A303 Amesbury to Berwick Down

8.2 Statement of Common Ground – The Environment Agency

A303 Amesbury to Berwick Down
Development Consent Order 2019

STATEMENT OF COMMON GROUND – The Environment Agency

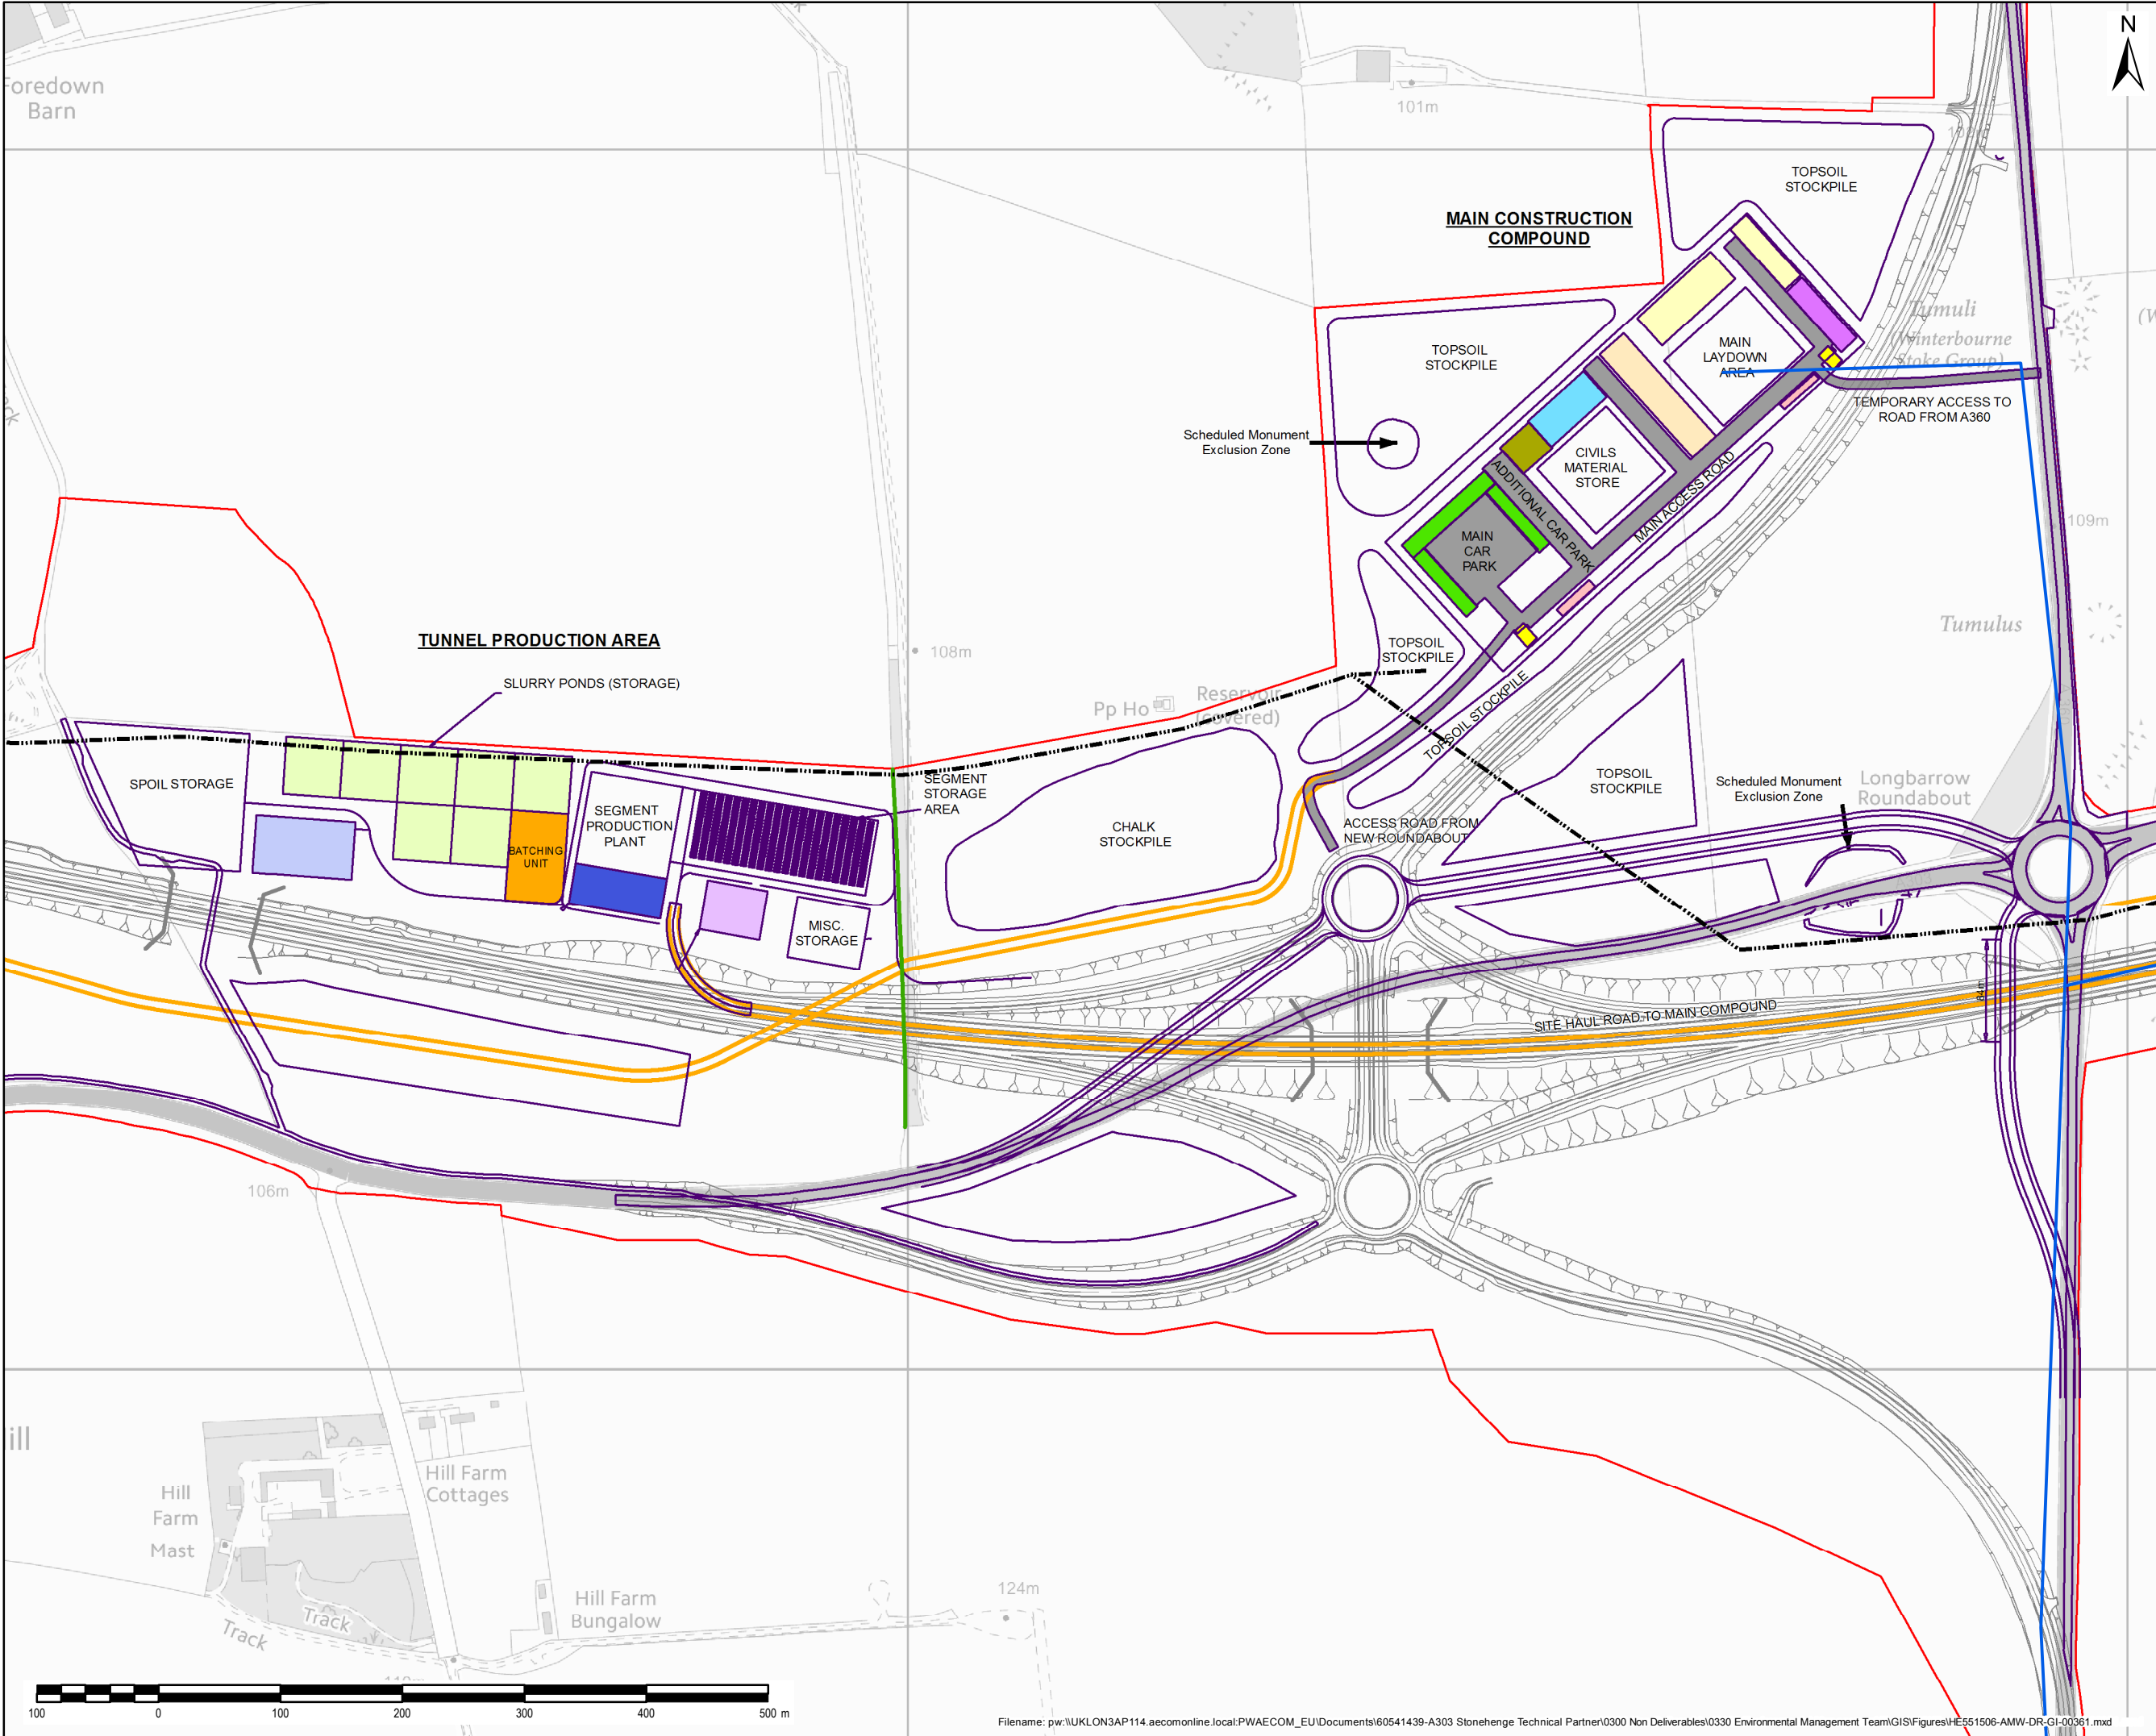
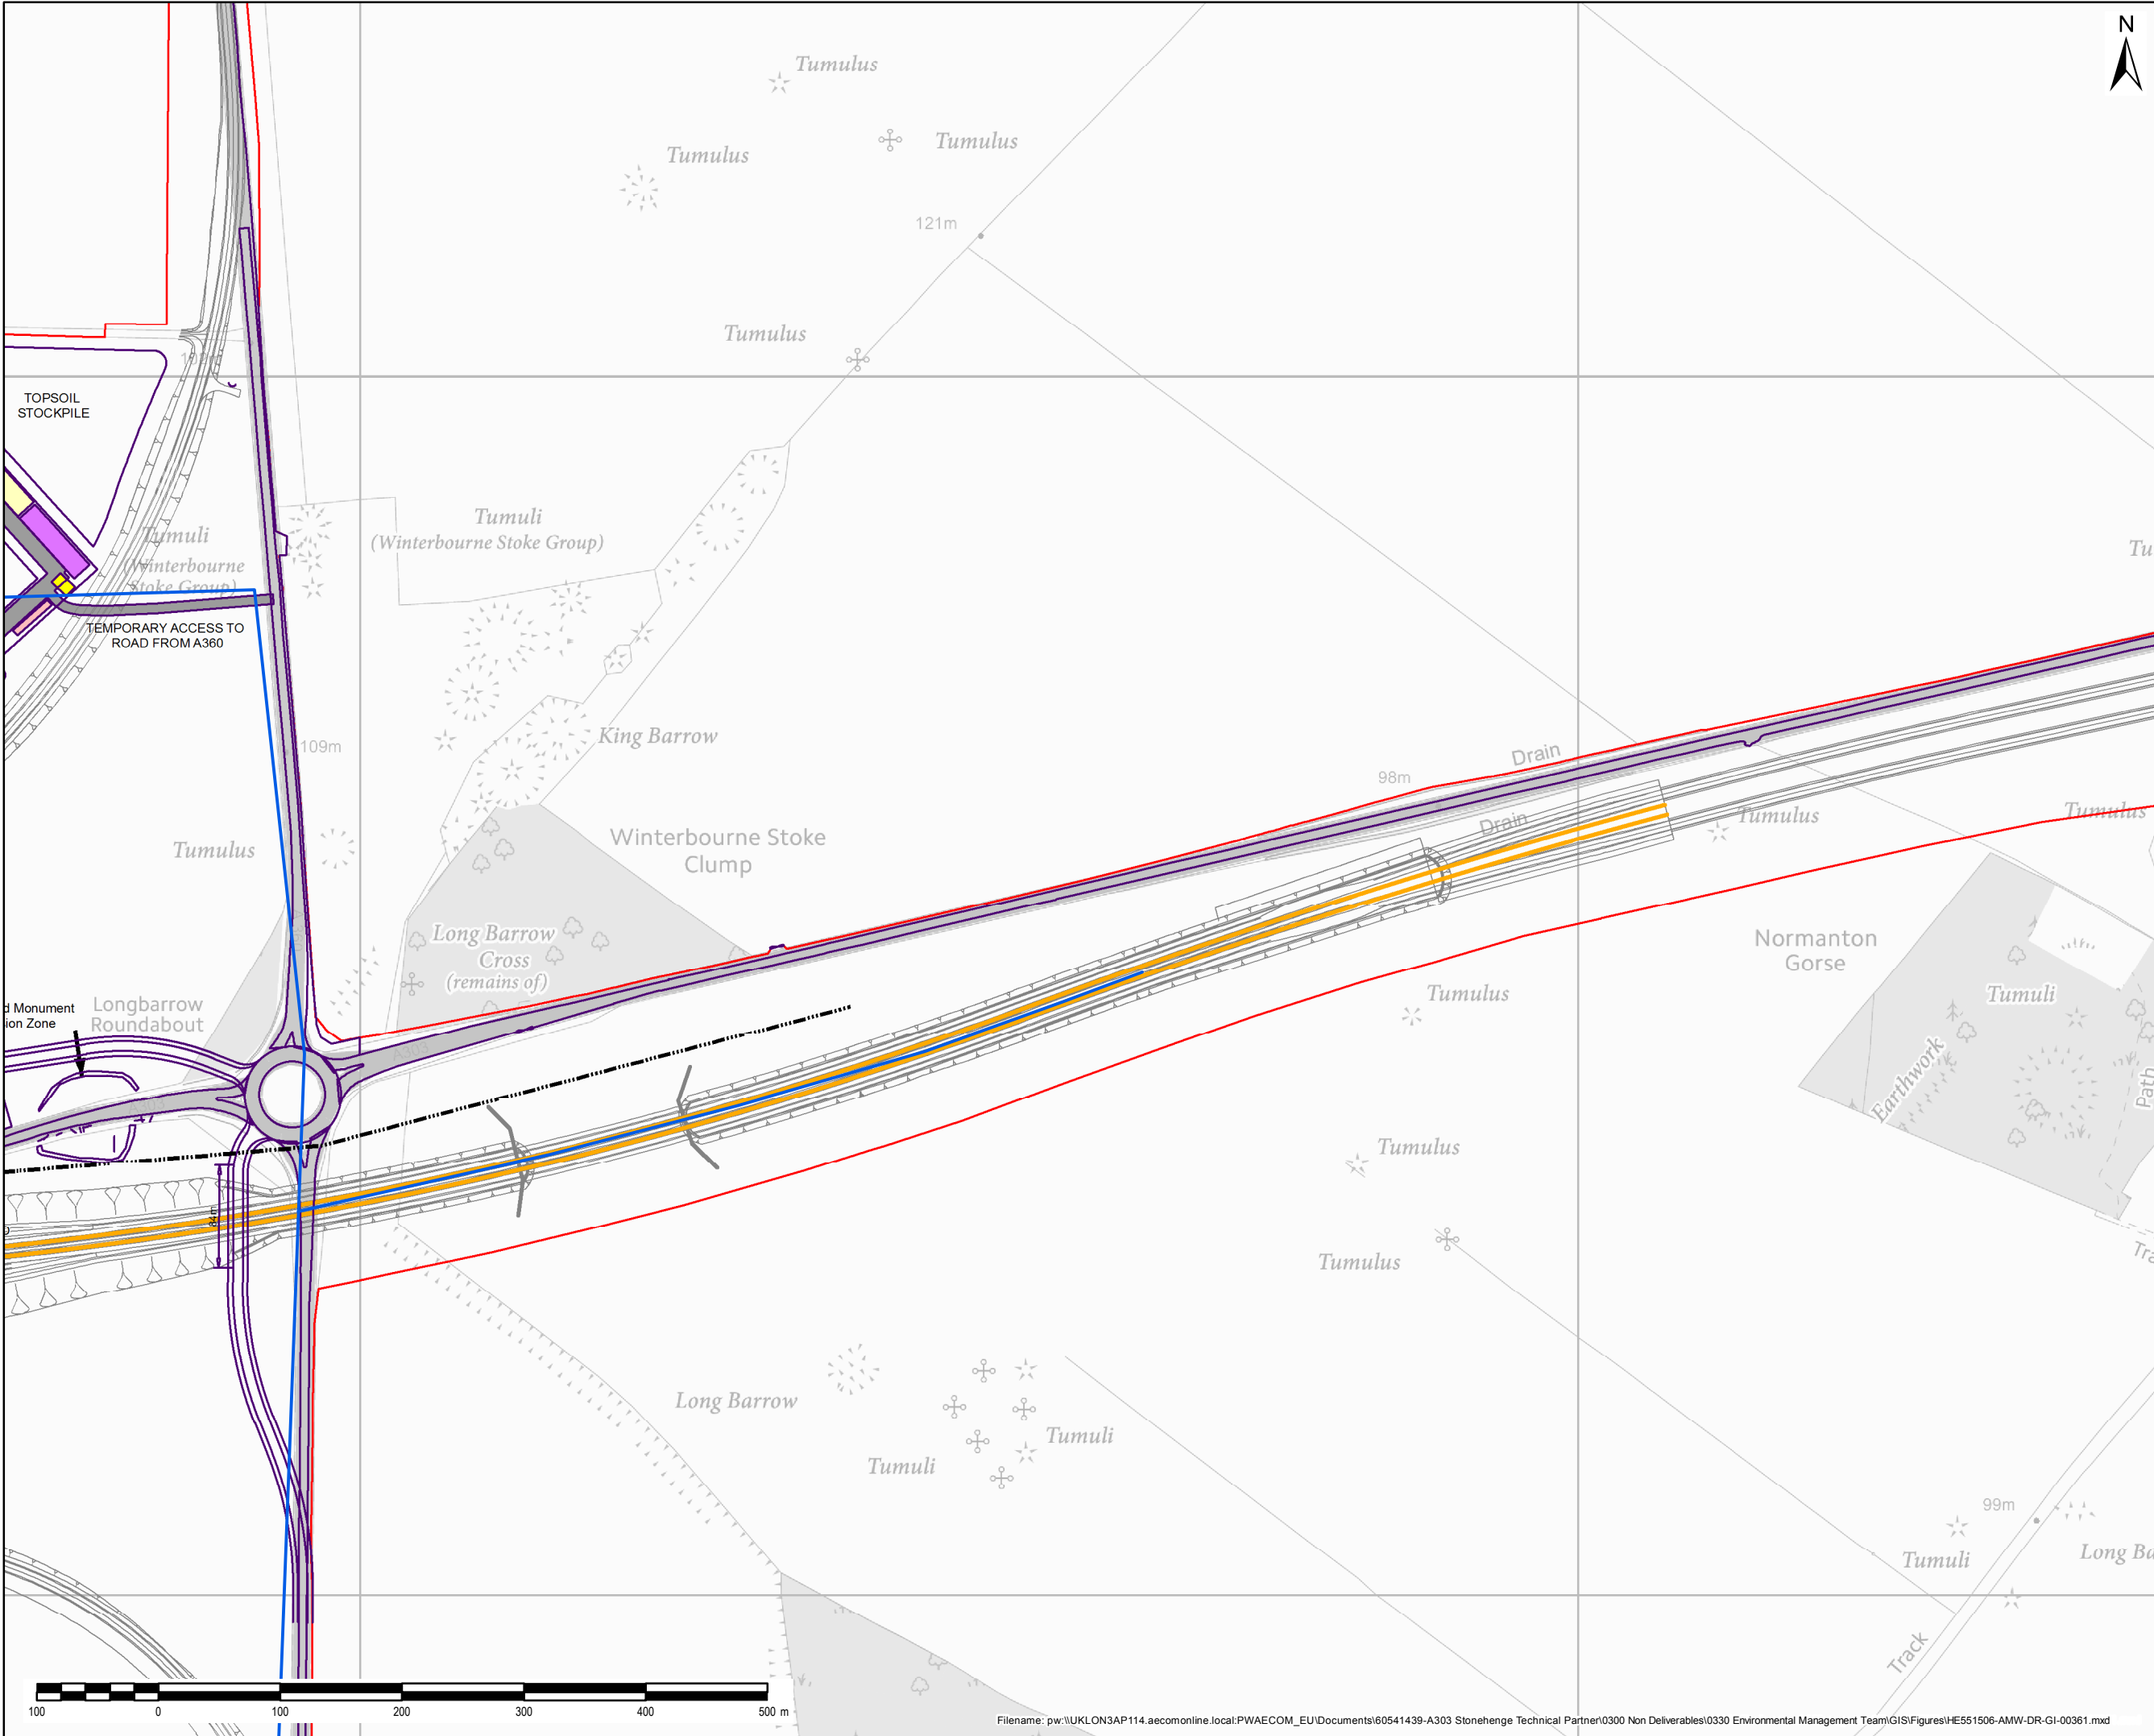
3.25	Flood risk	No temporary soil storage, other construction materials or construction site compounds located within Flood Zone 3 or known locations of high flood risk from surface water or groundwater.	The design of the Scheme locates soil storage, other construction materials and construction site compounds outside of Flood Zone 3 and away from known locations of high flood risk from surface water or groundwater (Figure 2.7 of the ES, APP-061).
